**Consultation Response from KC,
Lead Local Flood Authority**

**2023/93704 land northwest of, Urban Terrace, Denby Lane, Grange Moor, Huddersfield, WF4
4EB**

Erection of 10 dwellings and associated works

Date Responded: 26th February 2025

DO NOT SCALE	Scale @ A1: 250	Drawn	PAS	Checked	AE	Date	20.11.2023
Job No	Y22054	Dwg No	D900	Rev	5

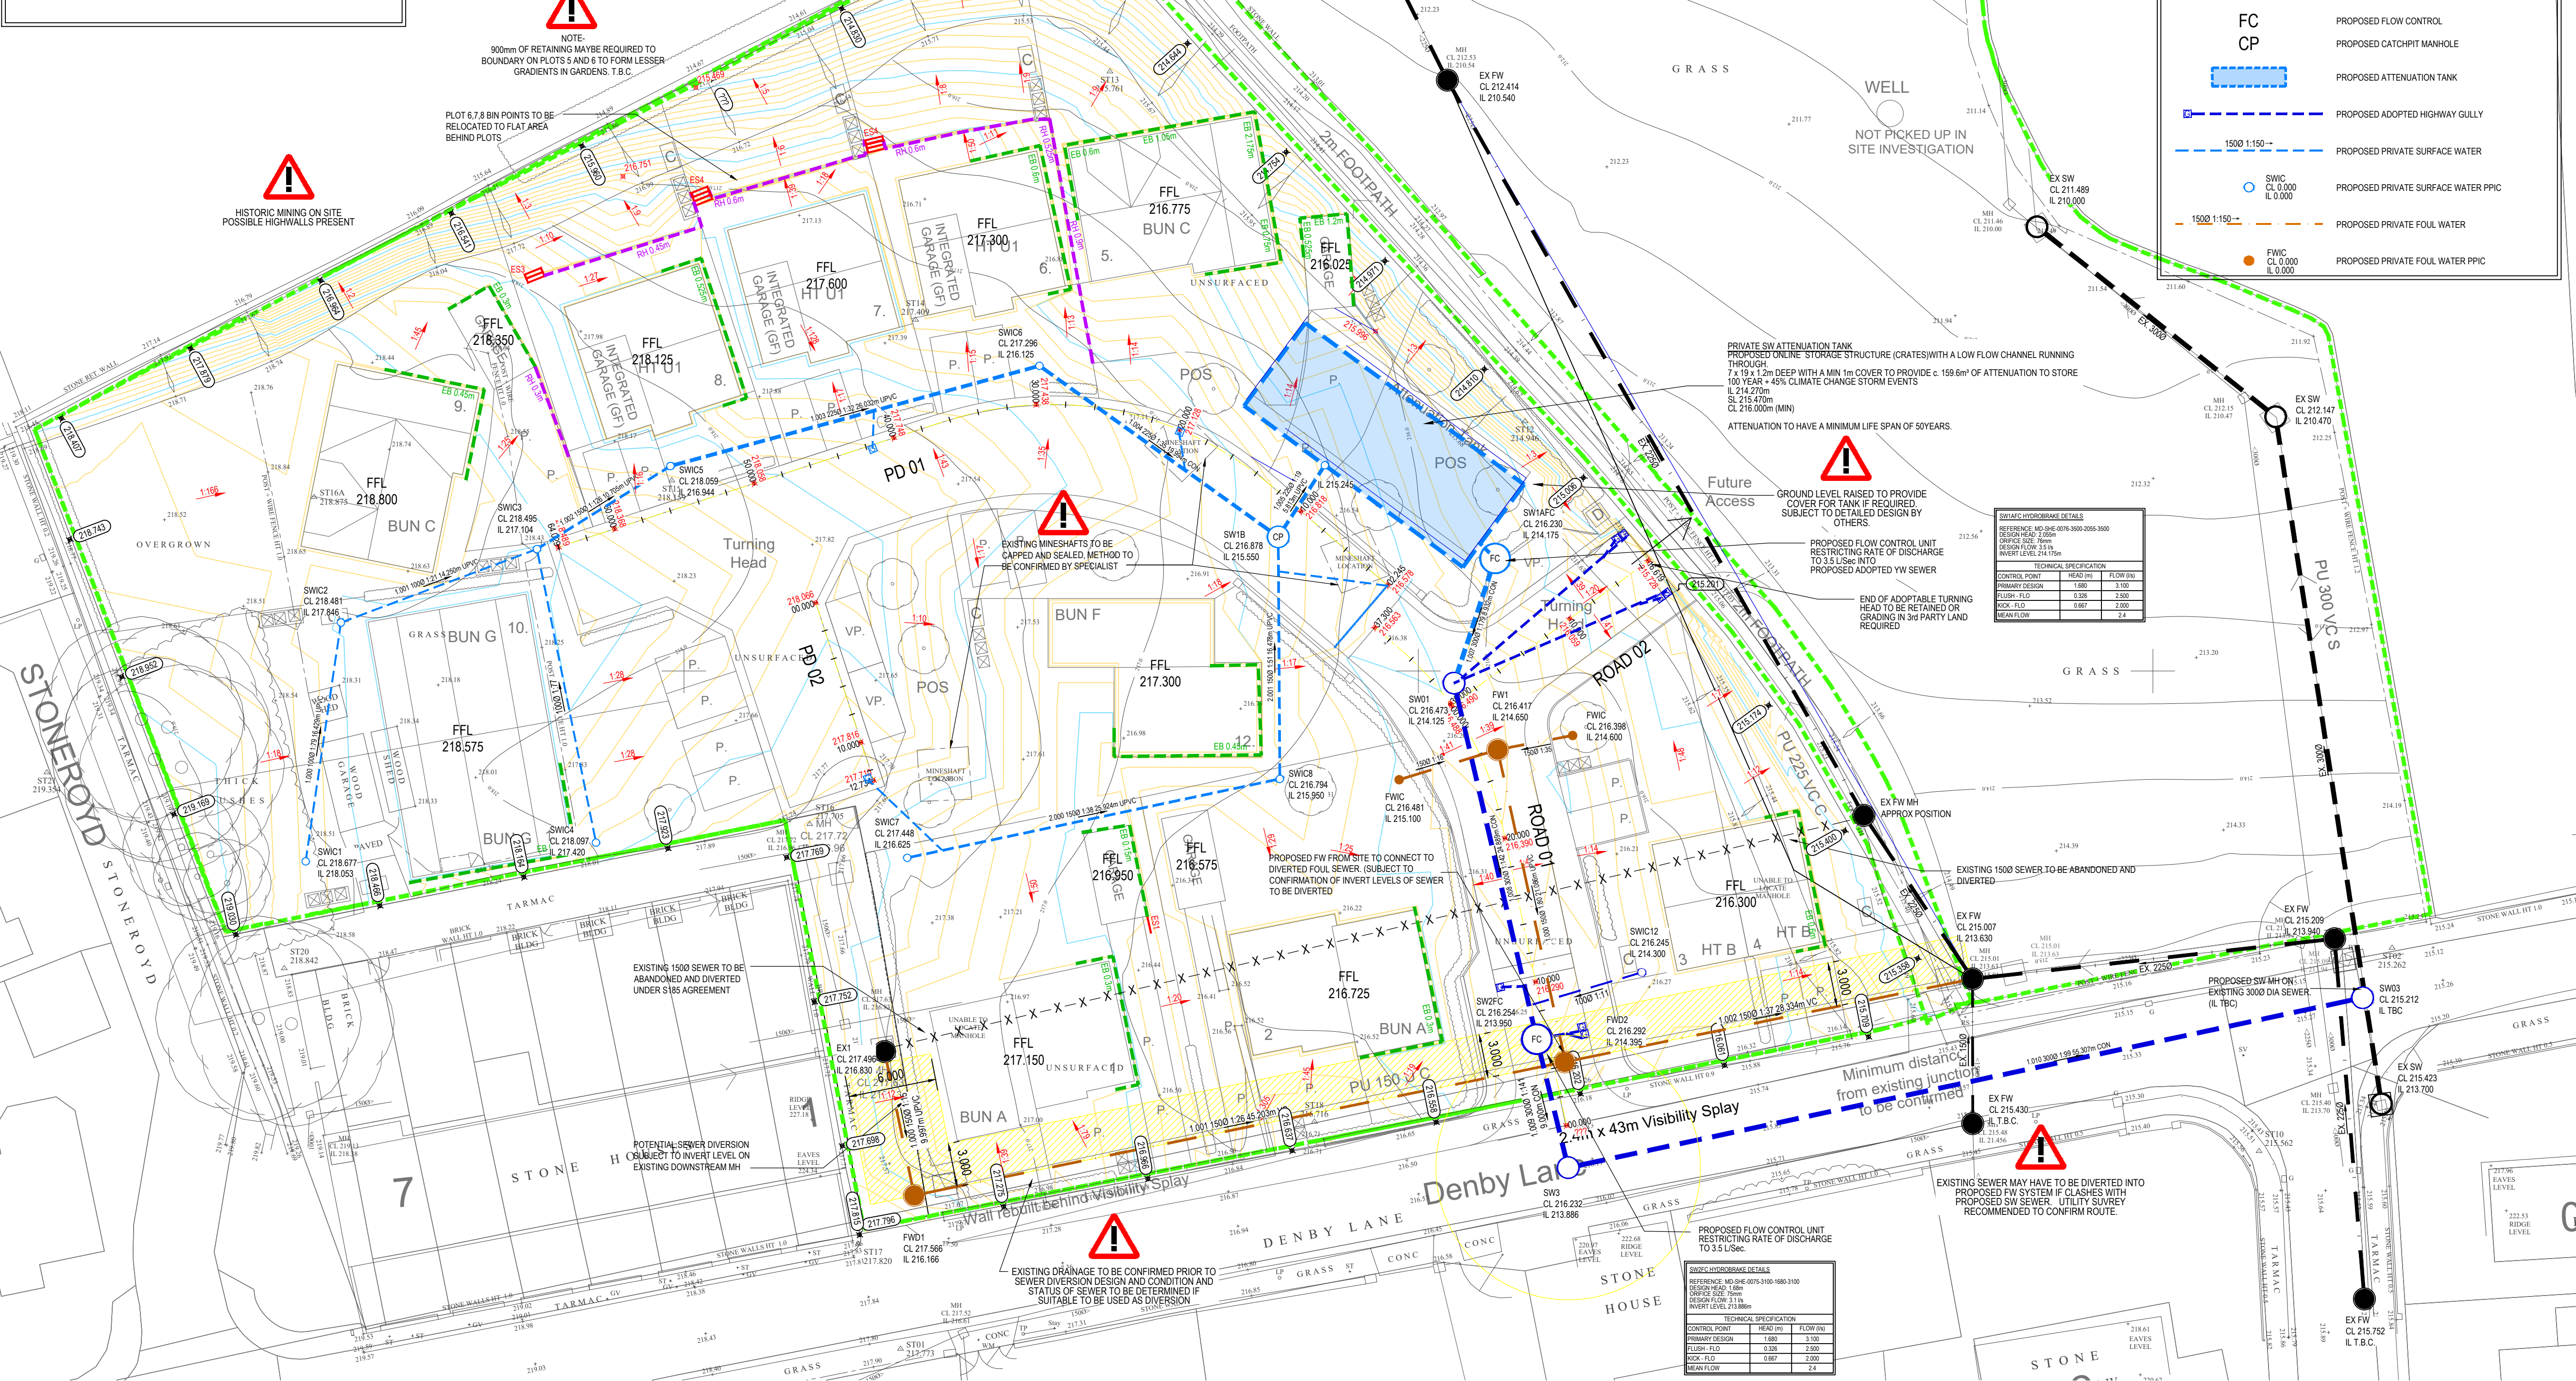
The planning officer should note that there are two Yorkshire Water 150mm diameter public sewers cross site. The joining together of these sewers, using a 150mm pipe has been proposed. Yorkshire Water must comment on the feasibility of this proposals including whether the joined pipe needs increasing to 225mm as per the downstream manholes, and stand-off distance required.

The use of crate storage for a surface water system that will remain private is discouraged due to the lack of guarantees over such systems and the difficulty in inspecting and cleaning them. As the LPA has a legal obligation to ensure that adequate suds are maintained and managed for the lifetime of the site using section 106 of the Town and Country Planning Act 1990, we believe there are better ways of achieving this. This is likely to cause difficulty in road adoption also. A design change is required in order to promote this site with a condition.

The infilled pond must be examined for incoming and outgoing pipes to see what it reveals as to what fed the pond and where did the water go. This is needed for a full assessment of the site.

1 Proposed Site Layout

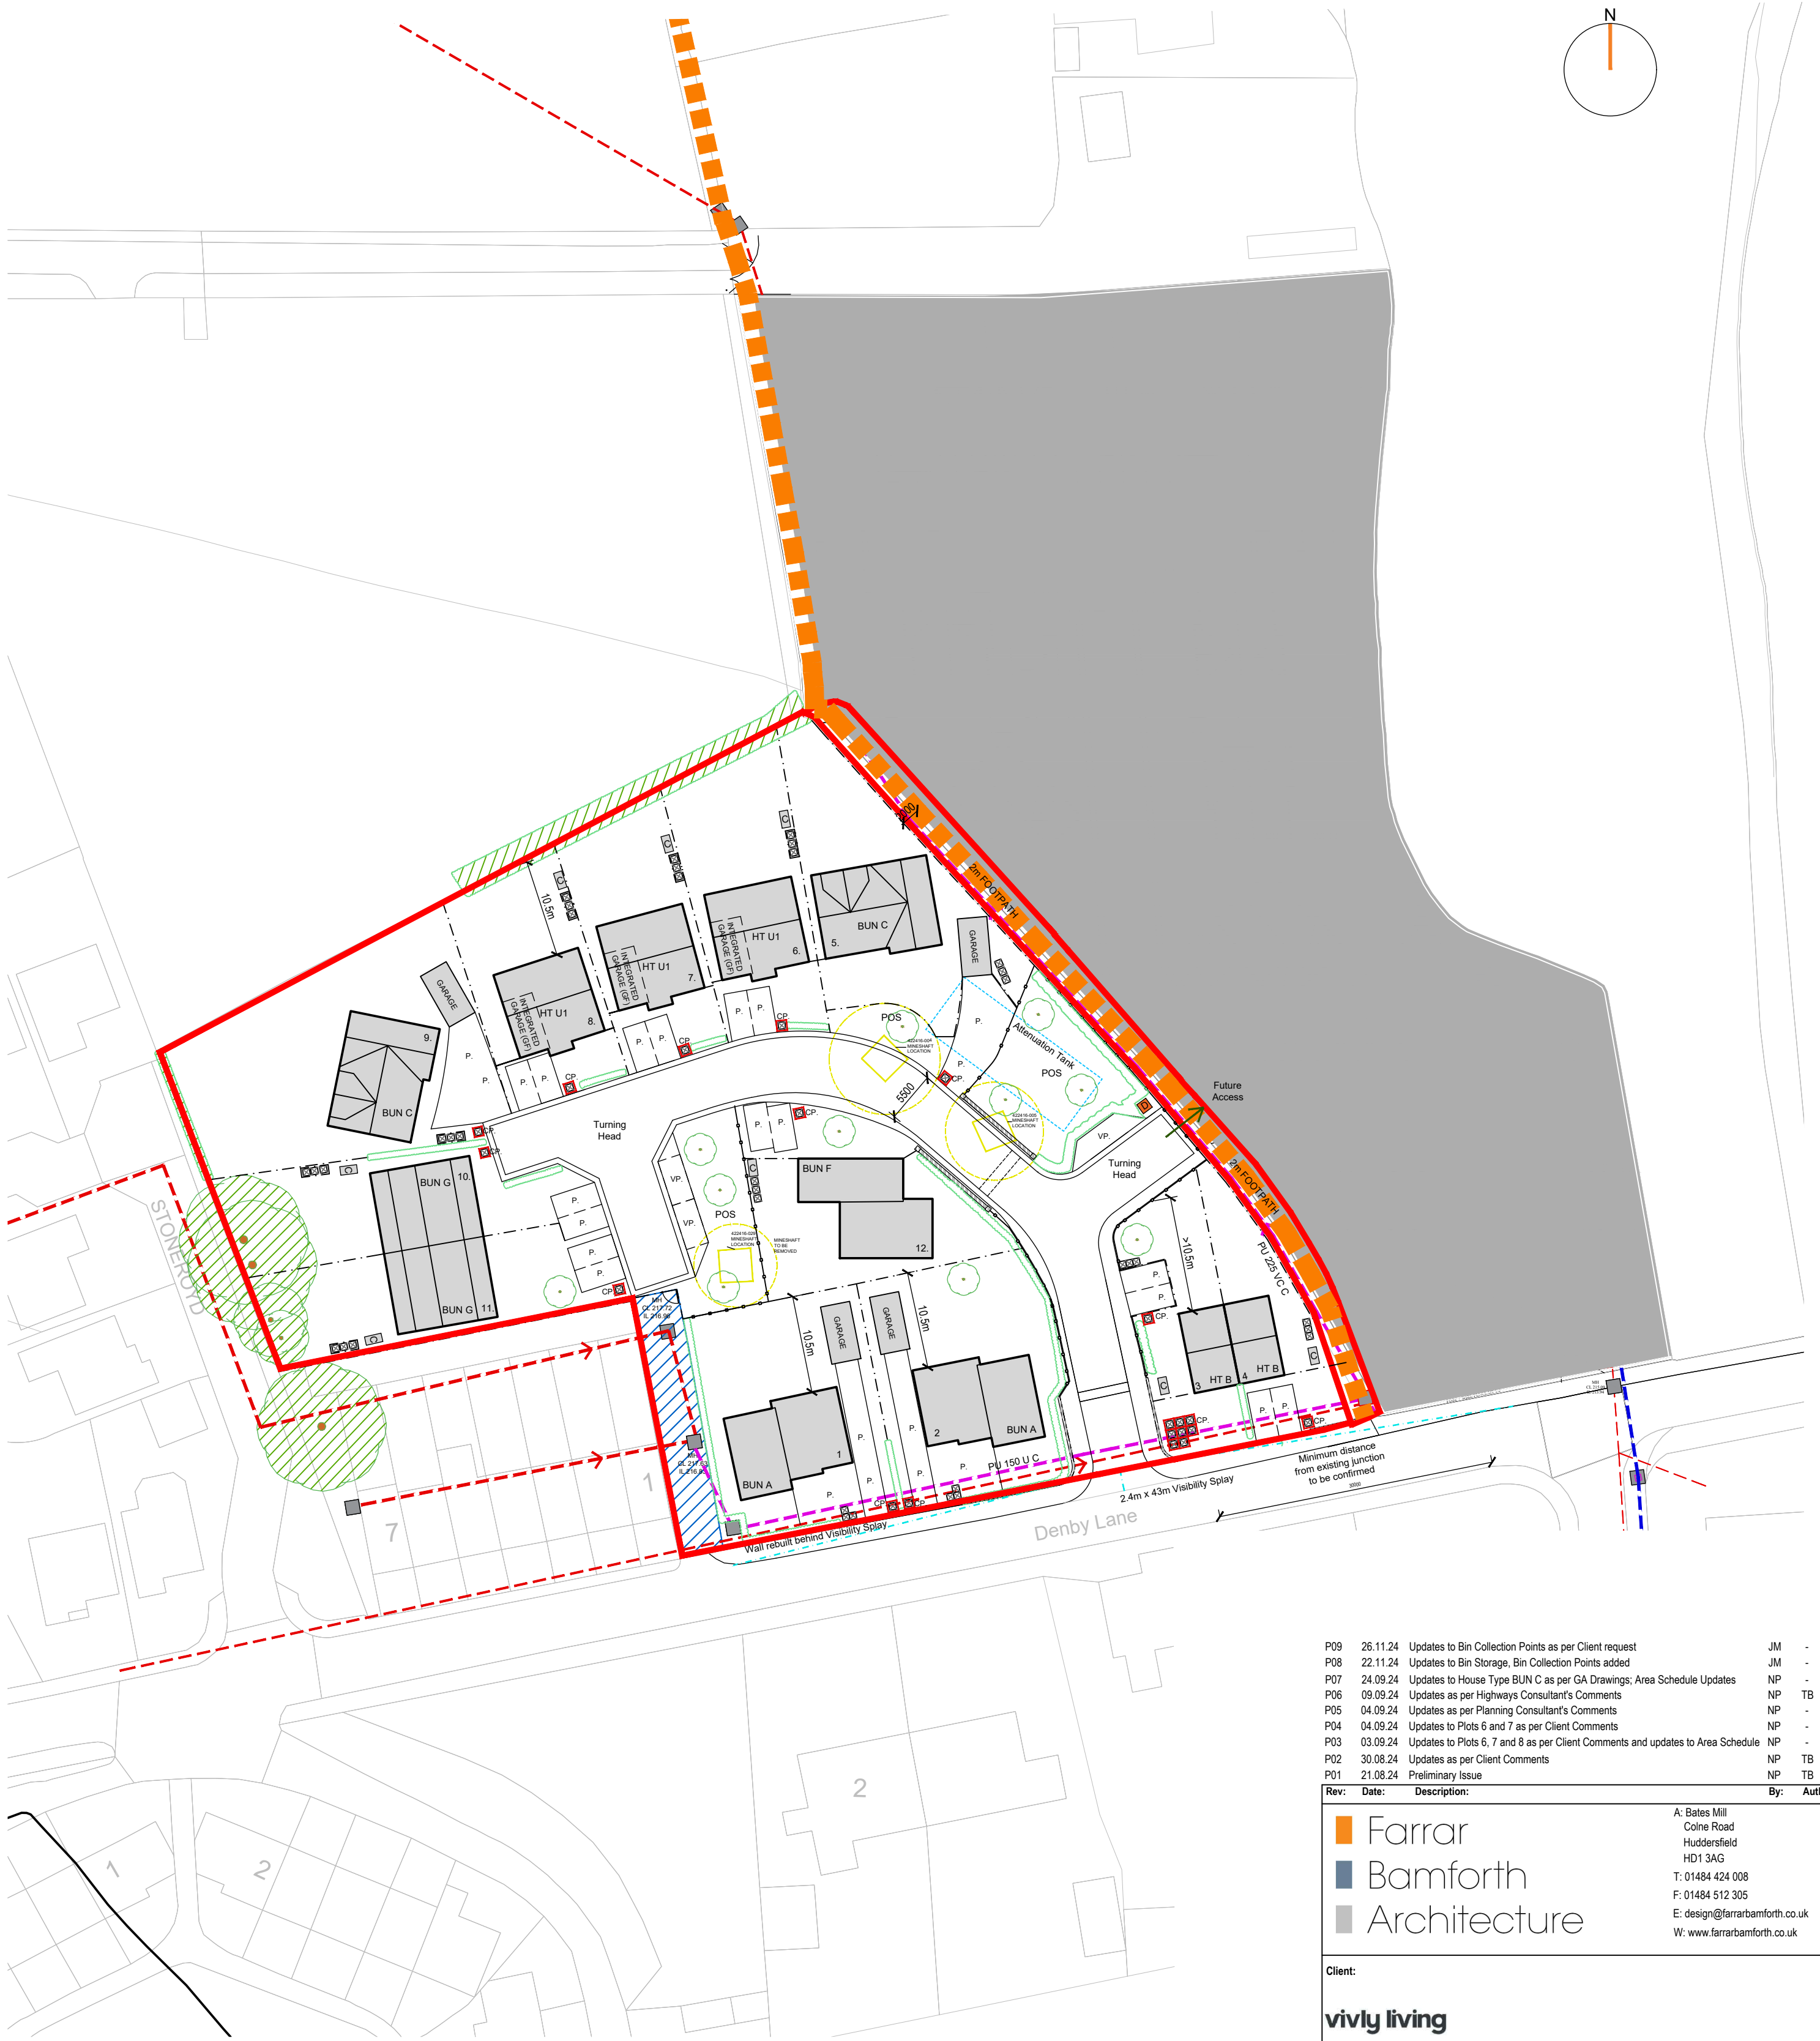
Flood routing will depend on the final agreed layout. At first look, a suitable flood routing scheme can be included on this site but a condition for final detail will be required.
